Application no: H17/0662/01

Description: Remove flat roof and erect
tiled roof to garage

Location: 31 Seas End Road
Surfleet
Spalding
Lincs

Amendment: Reduce ridge level by 600mm
dwg no. 210426B

Drawing No.
21042648

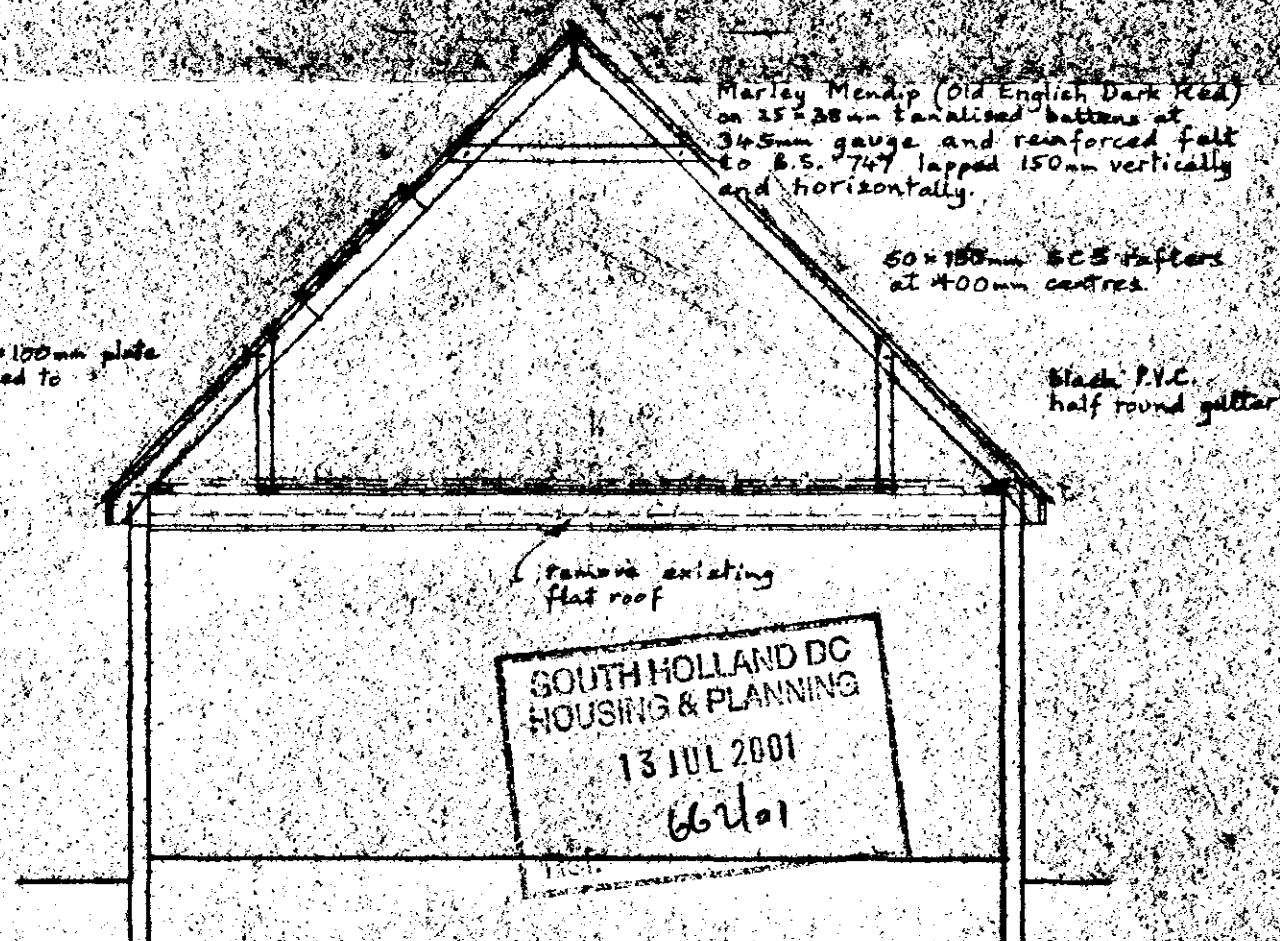
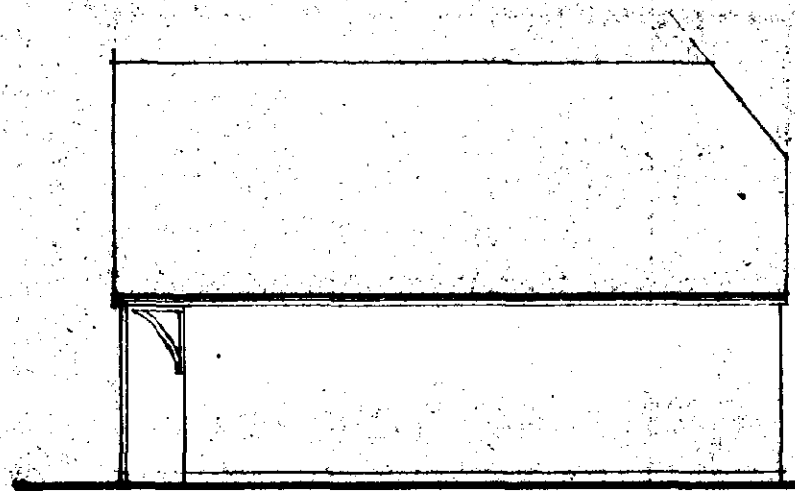
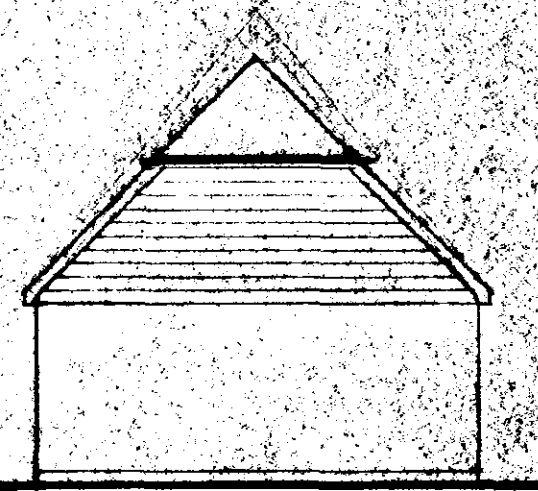
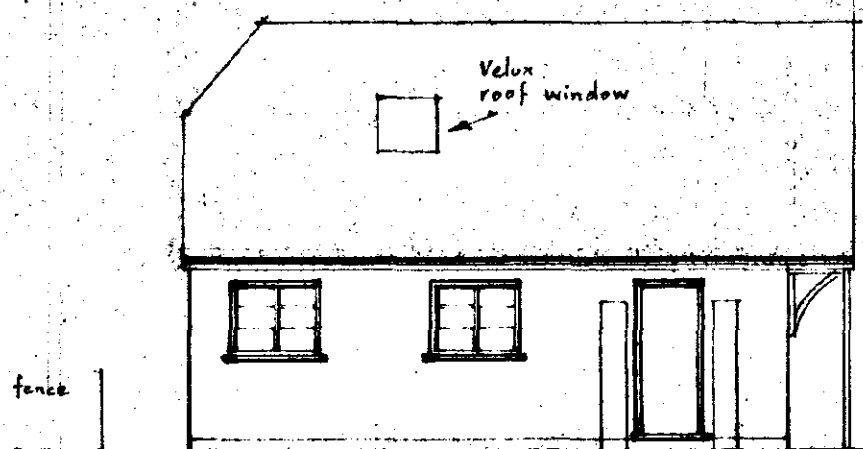
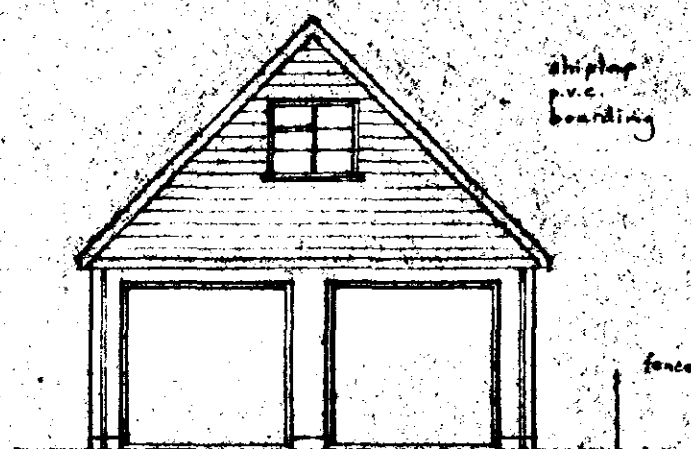
Reduce ridge level by 600mm
